**WEST SUSSEX COUNTY COUNCIL
PLANNING SERVICES CONSULTATION**

SUBJECT: LU/426/17/DOC - Approval of details reserved by condition imposed under LU/234/16/RES relating to condition 7 for details of acoustic barrier.

LOCATION: Fitzalan Link Road, East Street, Littlehampton, West Sussex.

Fitzalan Link
S278 Works: Landscape
Proposals 1 of 2

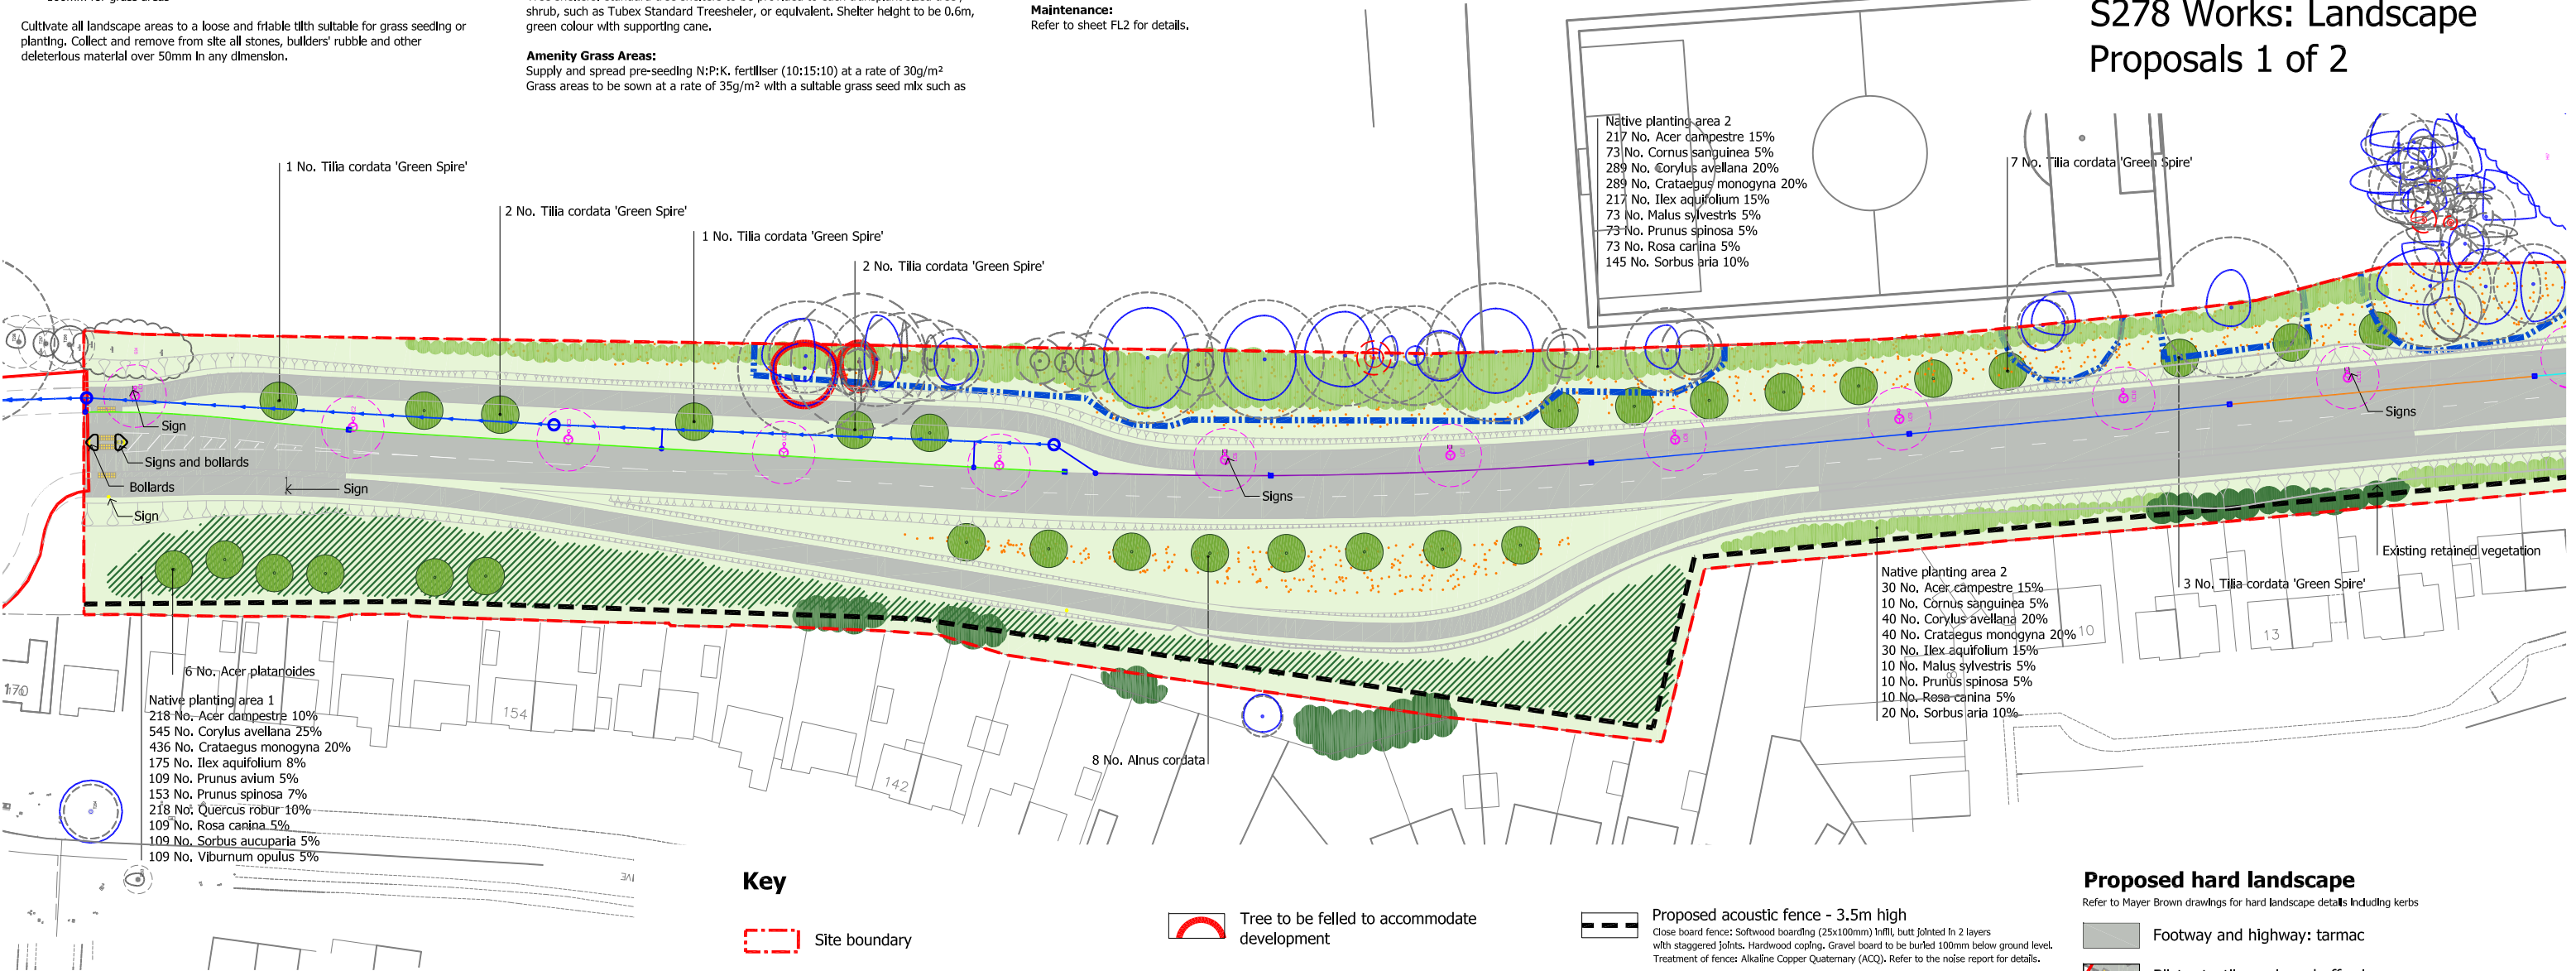
- 2. Conflicts with landscaping –** The location of some sections of the barrier appear to conflict with some existing trees and planting. How does the applicant intend to construct in these locations and provide access to planting and barrier either-side?

- 3. Planting –** Some of the planting annotated within limits of adoption and alongside shared walking and cycling routes is still shown as blackthorn (or similar). This poses issues when maintained because of thorns being cast-onto the paths. Applicant to revise this and remove such planting immediately adjacent to these paths (and annotate as such on revised plan).
